City of Albuquerque Stormwater Construction Site Inspection Report

General Information					
ESC File No.	M15E054	Project Name:	Veterans Integration Center		
NPDES Id. No.	NMR1005M1	Location:	2701 Mulberry St SE		
1/28/2025	Owner	Contractor			
Operator	NM Veteran Integration Centers		Hart Construction		
Contact name & title	Jerry Becker				
e-mail	jerry@steomaticnm.com				
Contact Phone #	505-991-4708				
COA Inspector	Chancellor English		Start/End Time:	315pm	
Construction Phase:	south addition				
Type of Inspection:	<input checked="" type="checkbox"/> Regular	<input type="checkbox"/> Storm Event	<input type="checkbox"/> Post Storm Event >0.25"	<input type="checkbox"/> 311/Complaint	<input type="checkbox"/> Follow Up
Weather at time of inspection?	Clear		Temperature: ~	57	
Estimated date of last storm 0.25" or greater	11/7/2024

ESC-1

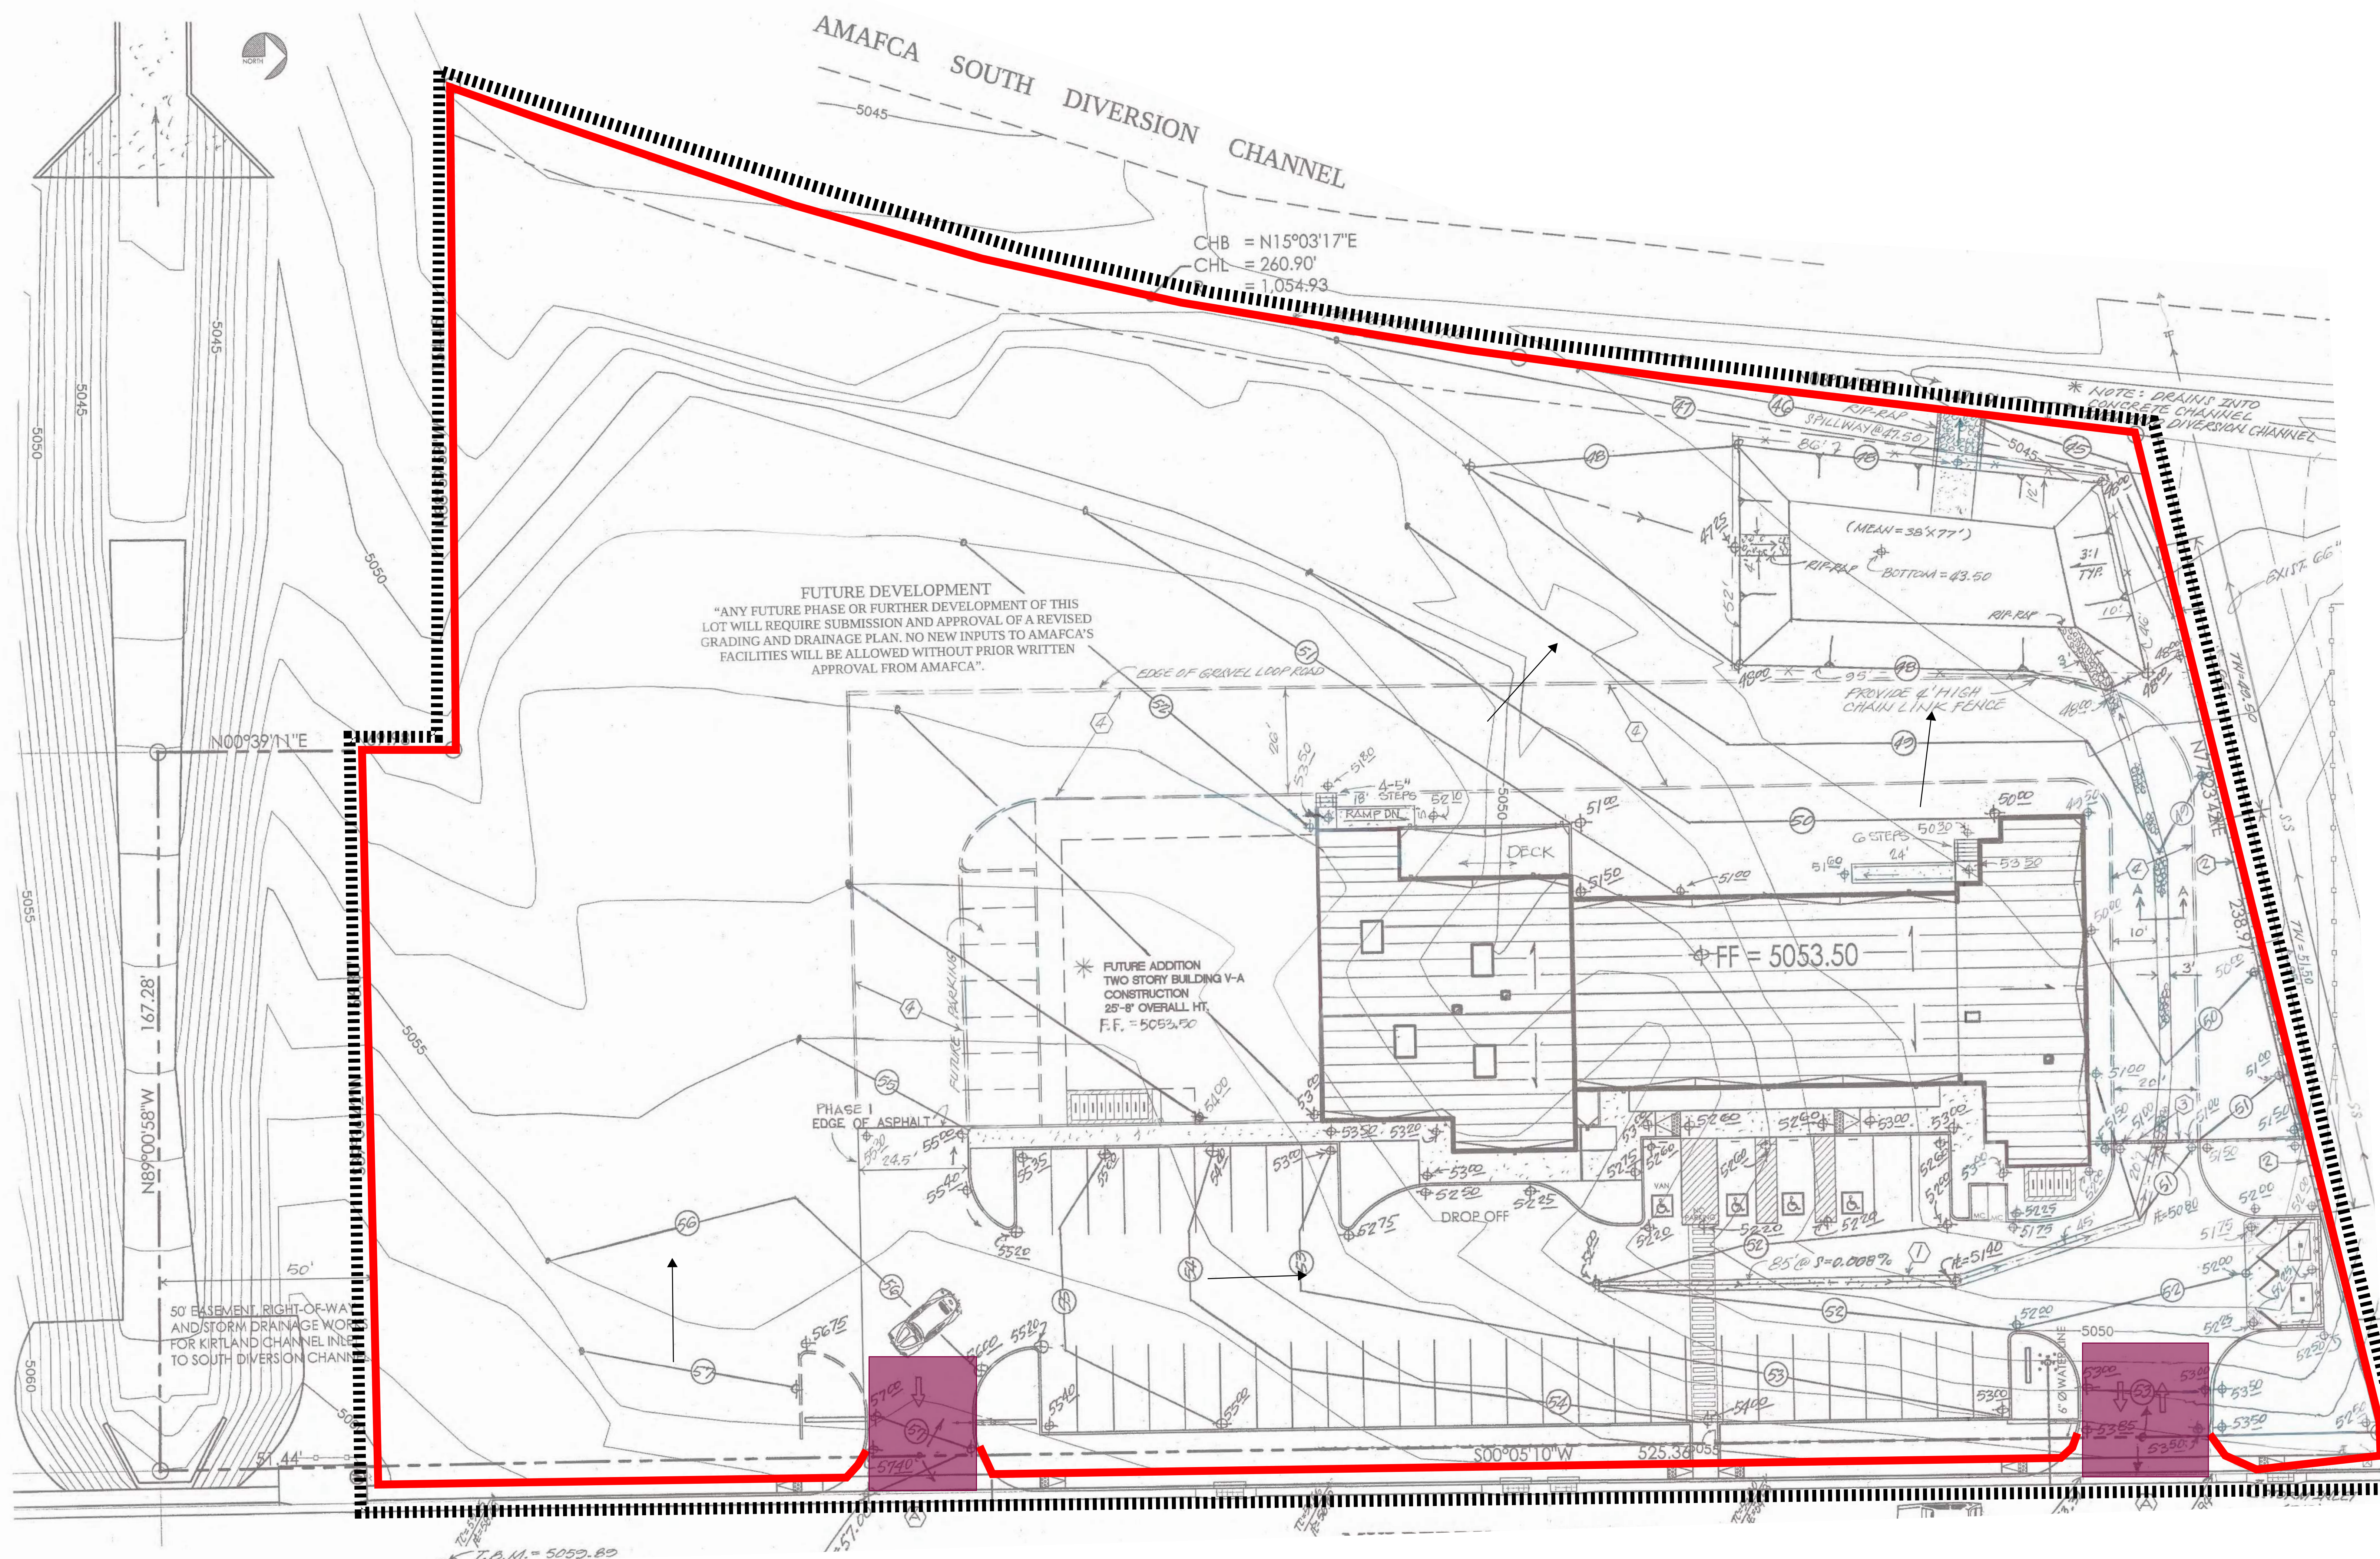
2.1	Discharge off site? (Y/N)	no			
4	Self Inspection Reports	No	Latest report Date:	N/A	
Notes:					
The general contractor has changed from Jaynes Corporation to Hart Construction. Hart Construction will need to include their NOI in the SWPPP.					
The concrete washout pit is full and needs to be emptied before it can be used again.
